Project No: ITB14679

Project Title: Land South of Ford Lane

Title: Stage 1 Road Safety Audit – GG119 Response Format

Ref: DS/ITB14679-006D

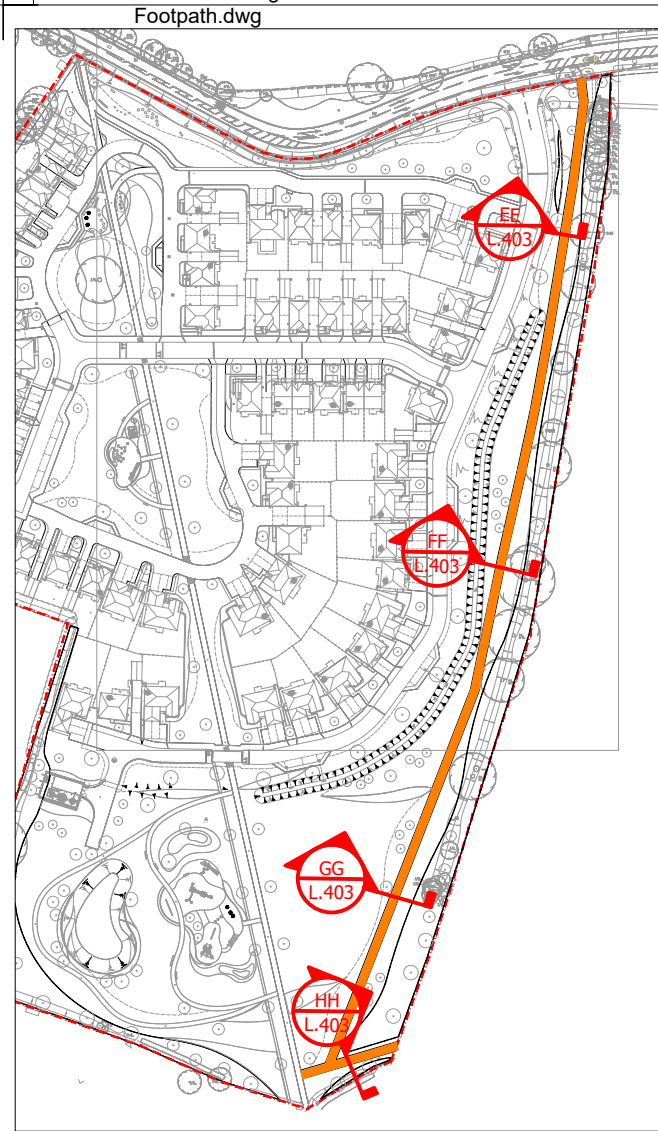
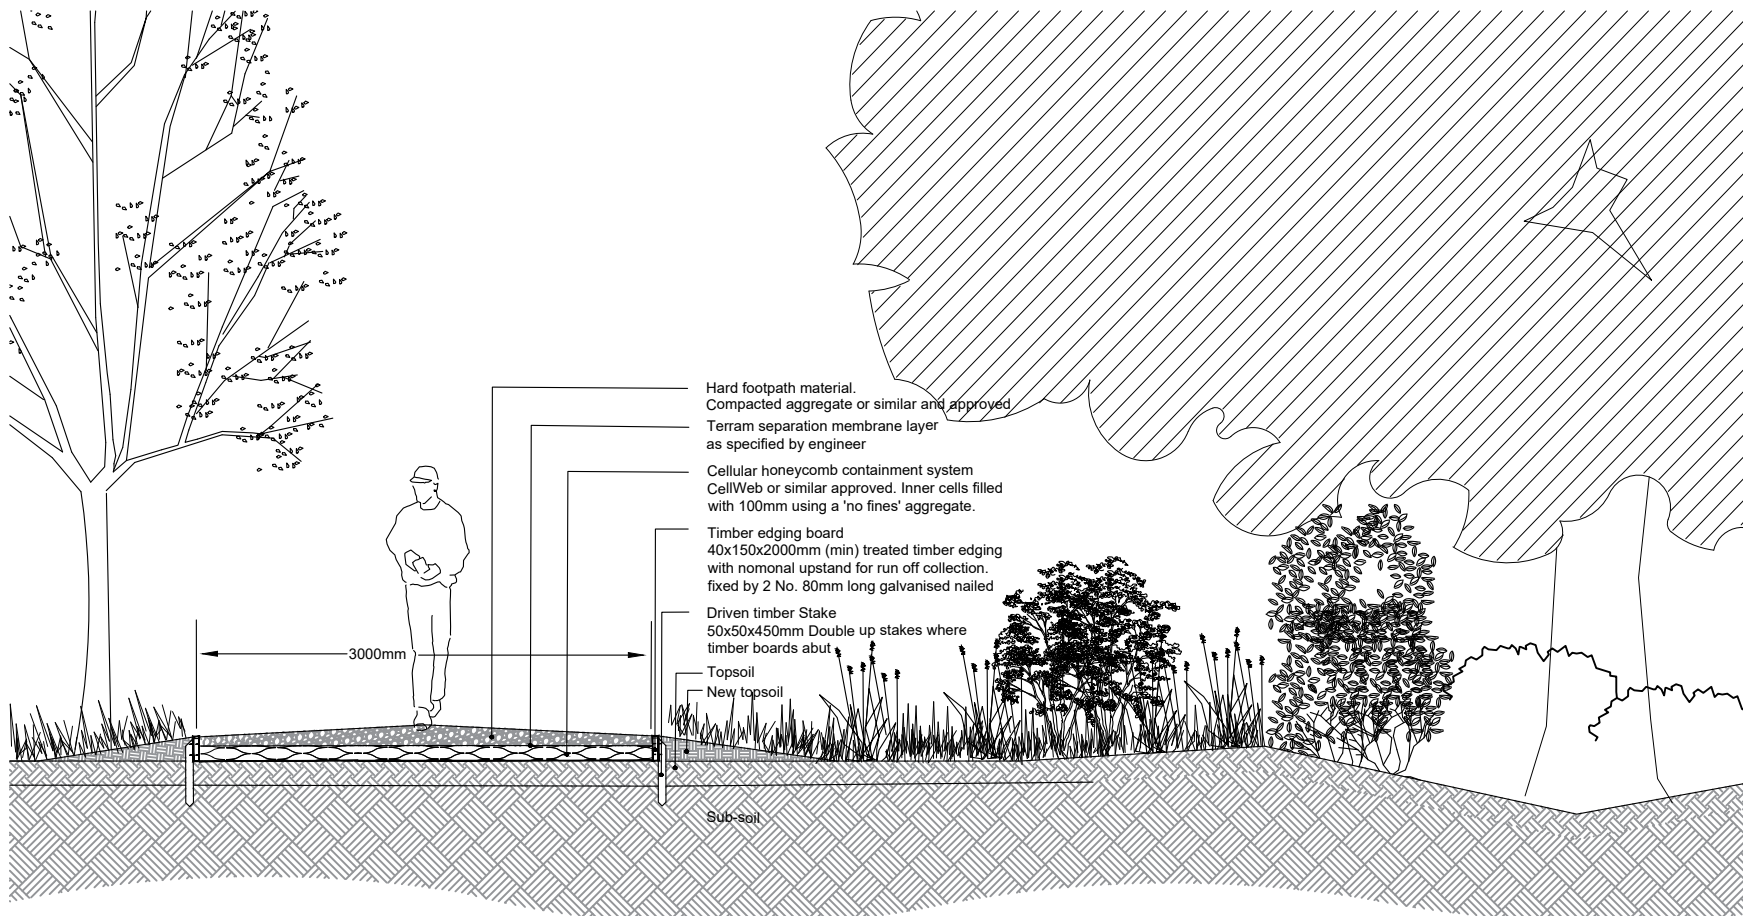
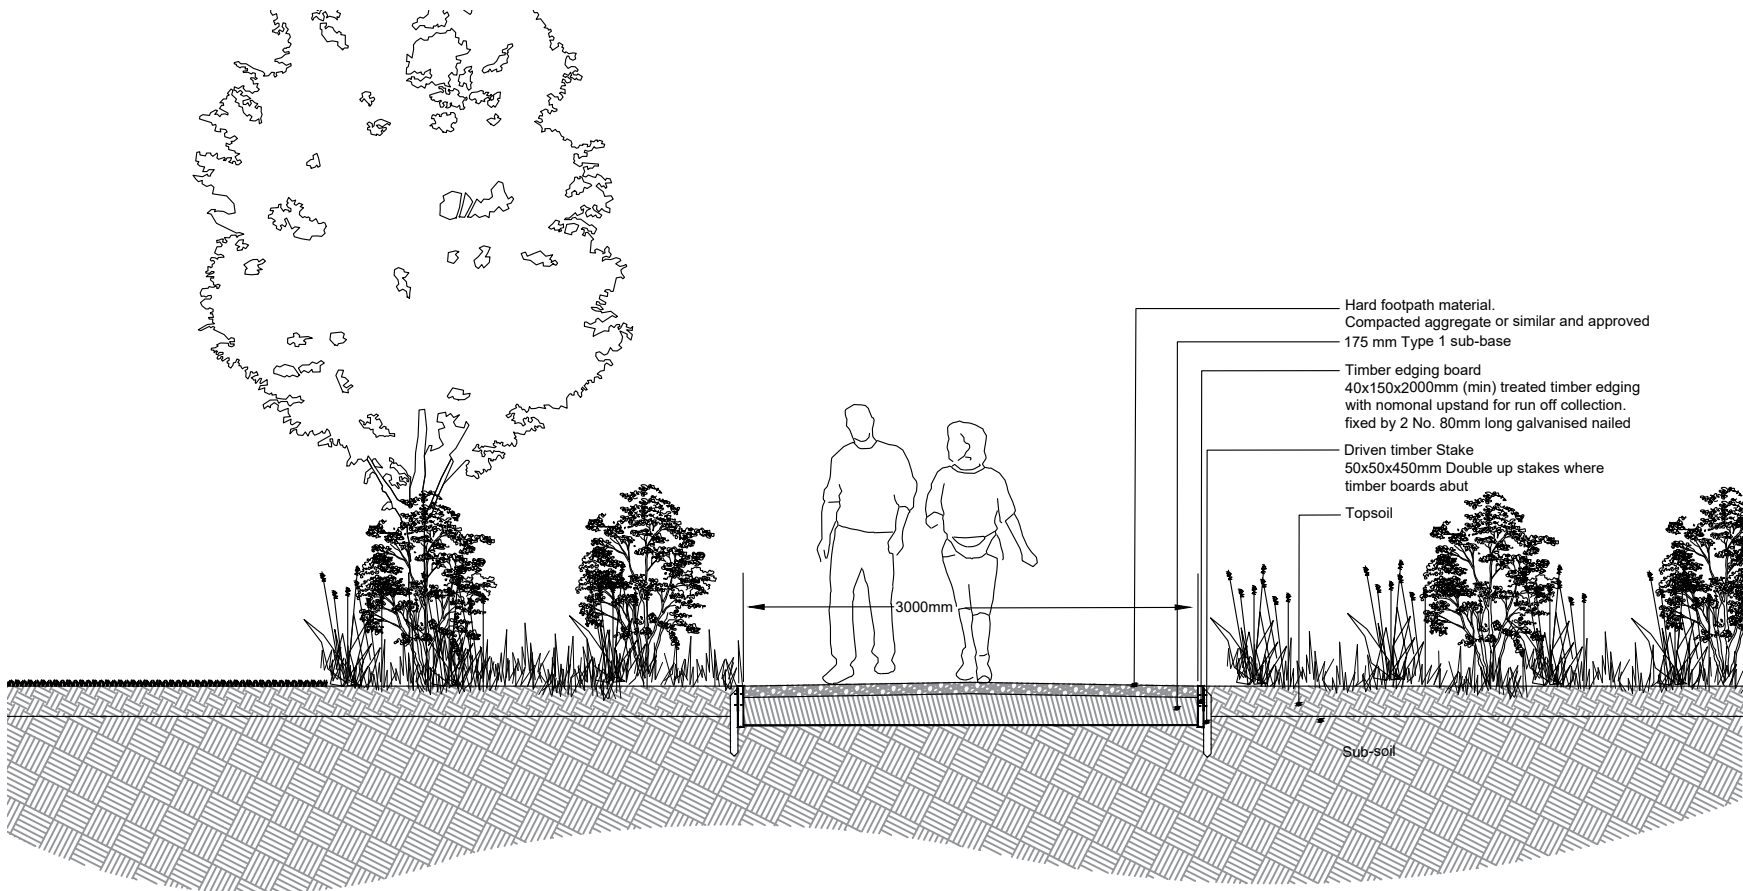
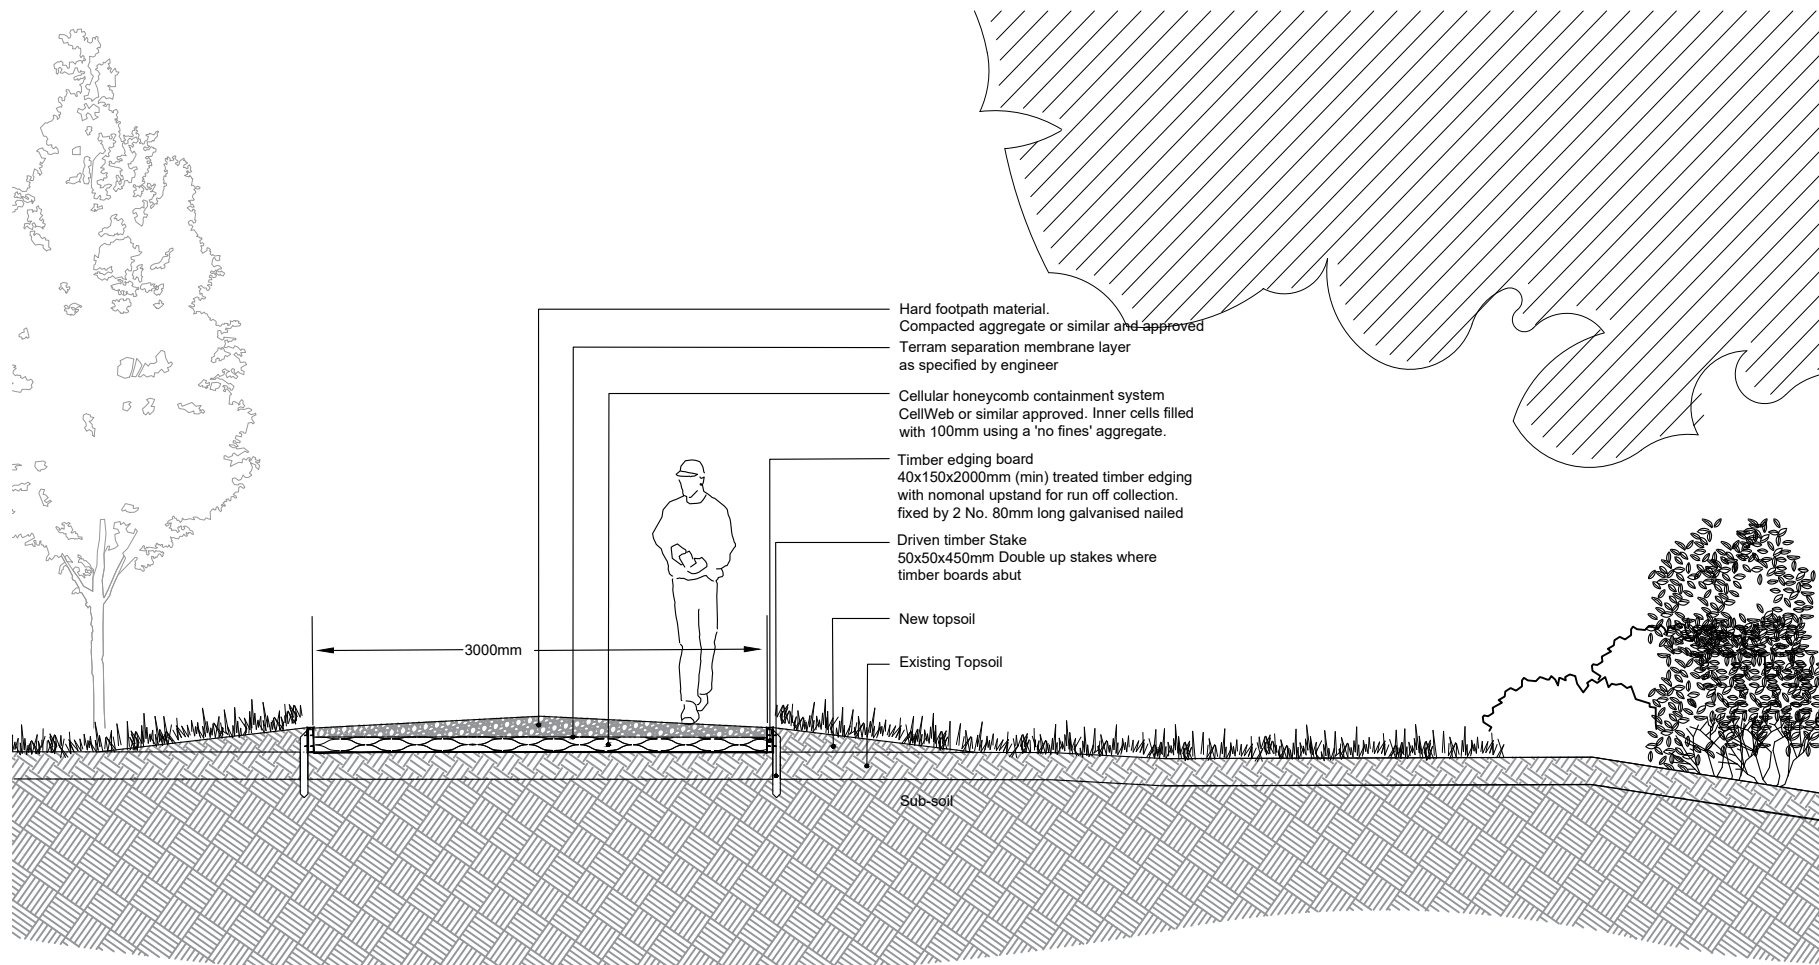
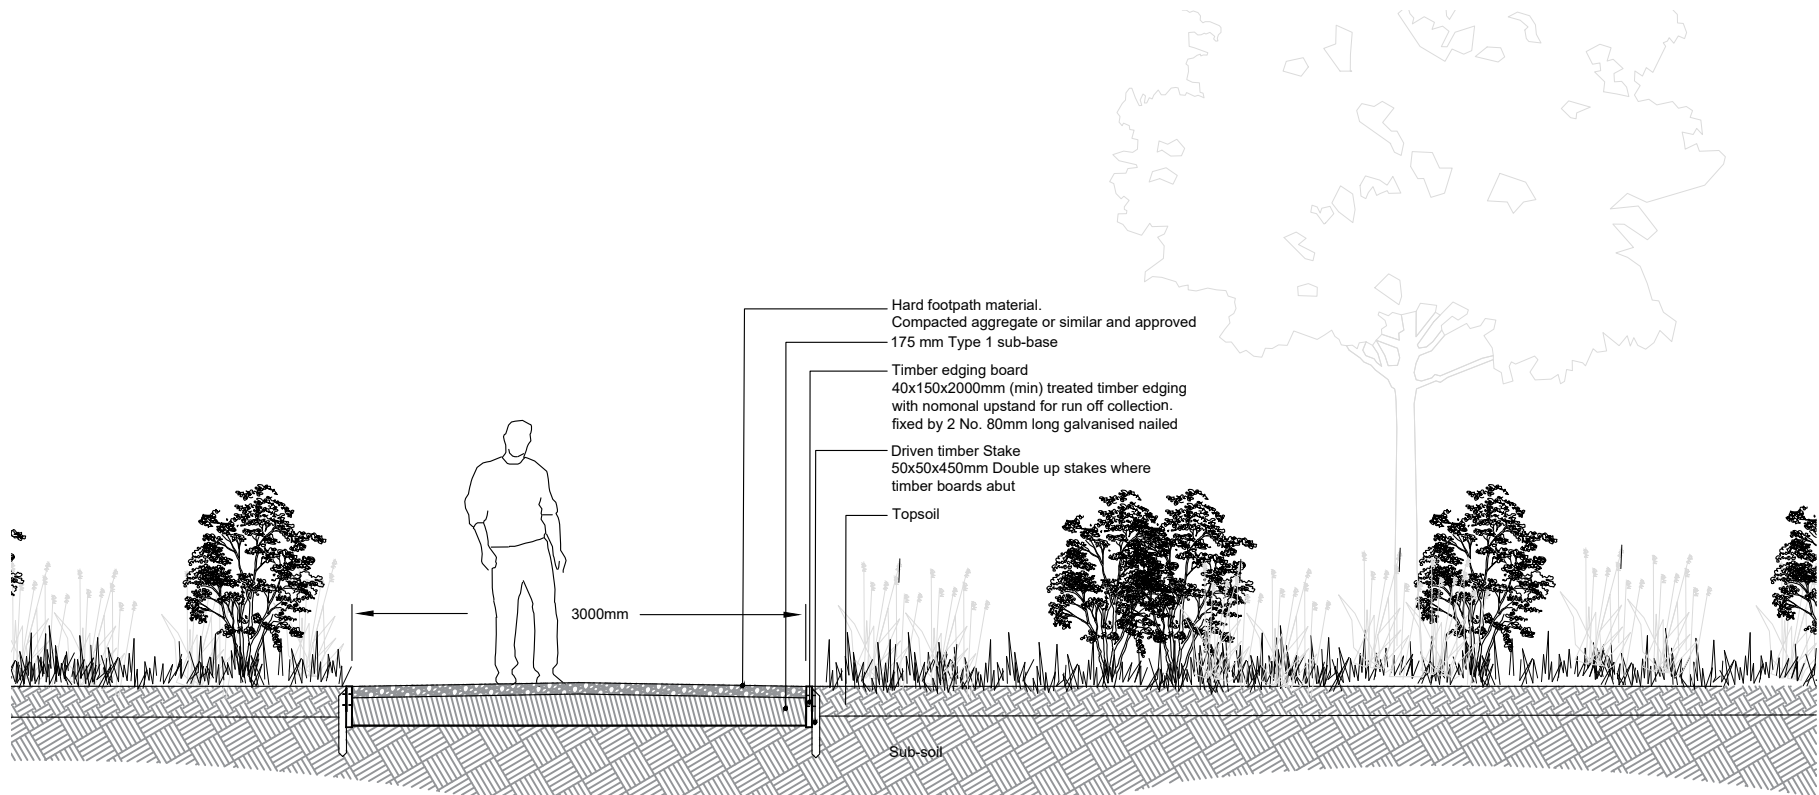
RSA Problem	RSA Recommendation	Design Organisation Response	Overseeing Organisation Response	Agreed RSA Action
4.1: The proposals that are subject of this Stage 1/2 Road Safety Audit include the provision of a surfaced 3 metre route for pedestrians through a proposed development between footpath 358 and Church Lane to the south and Ford Lane to the north as illustrated on dwg ITB16479-GA-002 revision B included with the Audit Brief. The proposed route is to cross the on-site roads that are to facilitate vehicular access, a number of times with two crossing of shared surface areas and two crossing of general carriageway where the crossing point is to be provided on a raised table. Each of the crossing locations is in-line where pedestrians walk towards the carriageway and are to consist of dropped kerbs that are understood to include an upstand of between 0 and 6mm and benefit from tactile paving. However, as illustrated on the scheme drawings, a minimum of two rows of tactile paving slabs are to be provided allowing for a minimum depth of 0.8 metres. Pedestrians could step across two rows of tactile paving and as such, visually pedestrians could enter the carriageway without warning. The crossing points are to be provided at shared surface areas or where raised tables are provided and as such, vehicles should be proceeding with caution at a low speed, however, a pedestrian entering the carriageway and the path of a vehicle without warning, could lead to vehicle pedestrian collisions. Furthermore, no tactile warning surface is provided adjacent to the stepped access to Ford Lane which could lead to pedestrians falling down the steps into the carriageway	It is recommended that tactile paving is provided for a minimum depth of 1.2 metres where pedestrians walk towards a hazard i.e. carriageway of steps.	Accepted – tactile paving depth as been increased to a minimum of 1.2m through the scheme, and additional tactile paving has been incorporated on FP357 on the approach to Ford Lane. The amendments are presented in drawing ITB14679-GA-002 Rev G.	Accepted.	Tactile paving to be provided at a depth of 1.2m as shown in drawing ITB14679-GA-002 Rev G.
